**Consultation Response from KC,
Highways Development Management**

2024/92003 Land adj, 130, North Street, Lockwood, Huddersfield, HD1 3SQ

Outline application for residential development with associated parking and soft landscaping

Date Responded: 17/08/2024.

PROPOSED SITE PLAN 1:50 @ A1

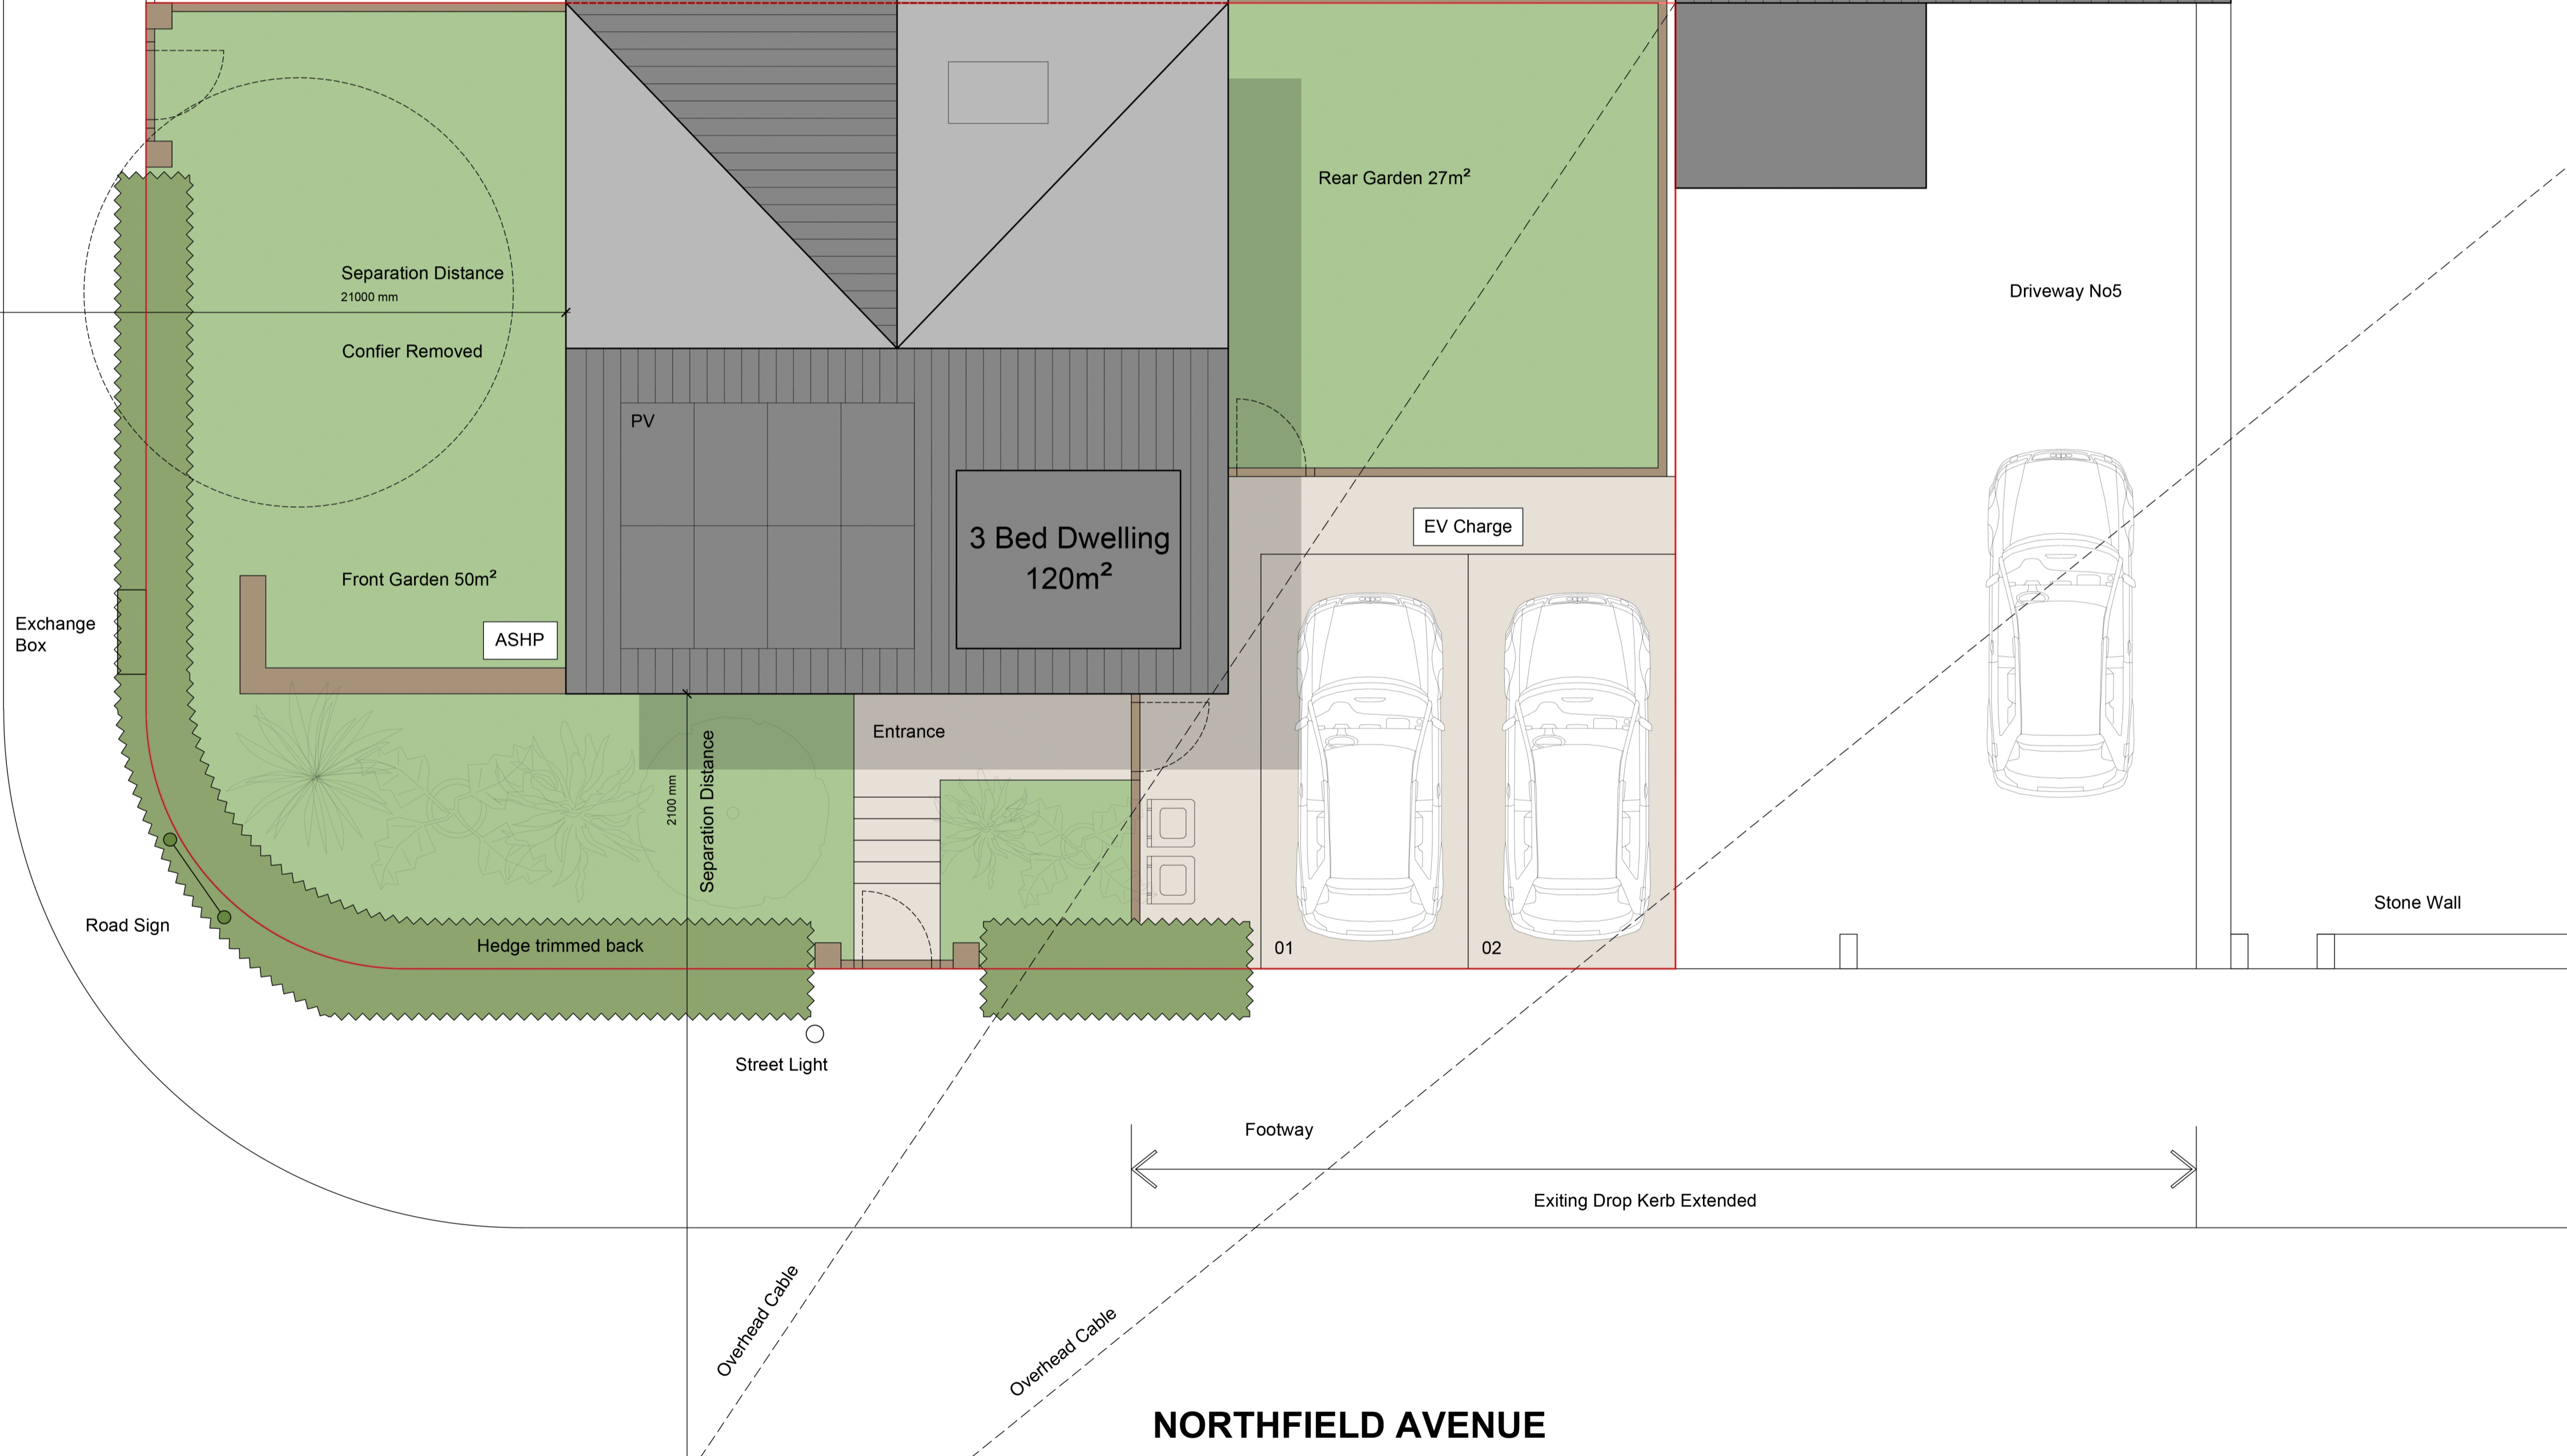
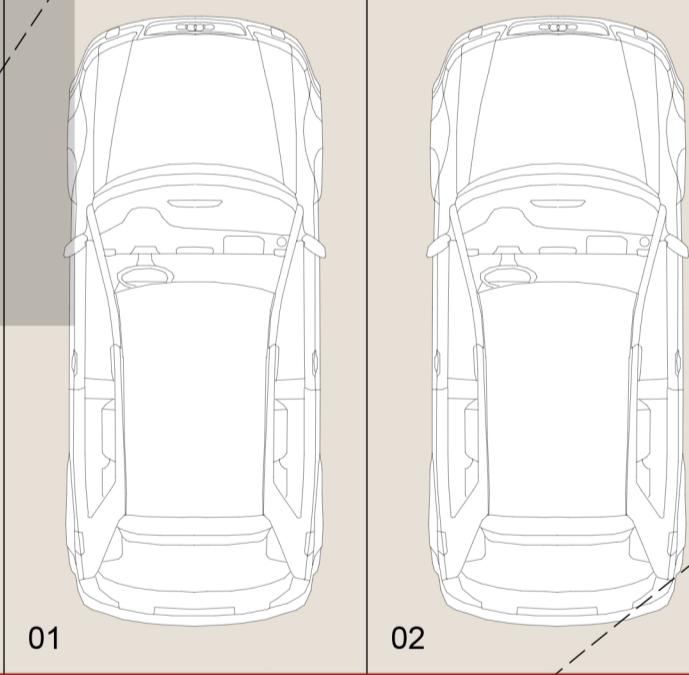
Two car parking spaces are proposed, which is acceptable for a three bedroomed house.

A new vehicle access is proposed onto Northfield Avenue is proposed and is acceptable.

The existing sightlines at the junction of Northfield Avenue and North Street should be maintained.

A bin storage area and collection/presentation point are shown on the plan and is acceptable.
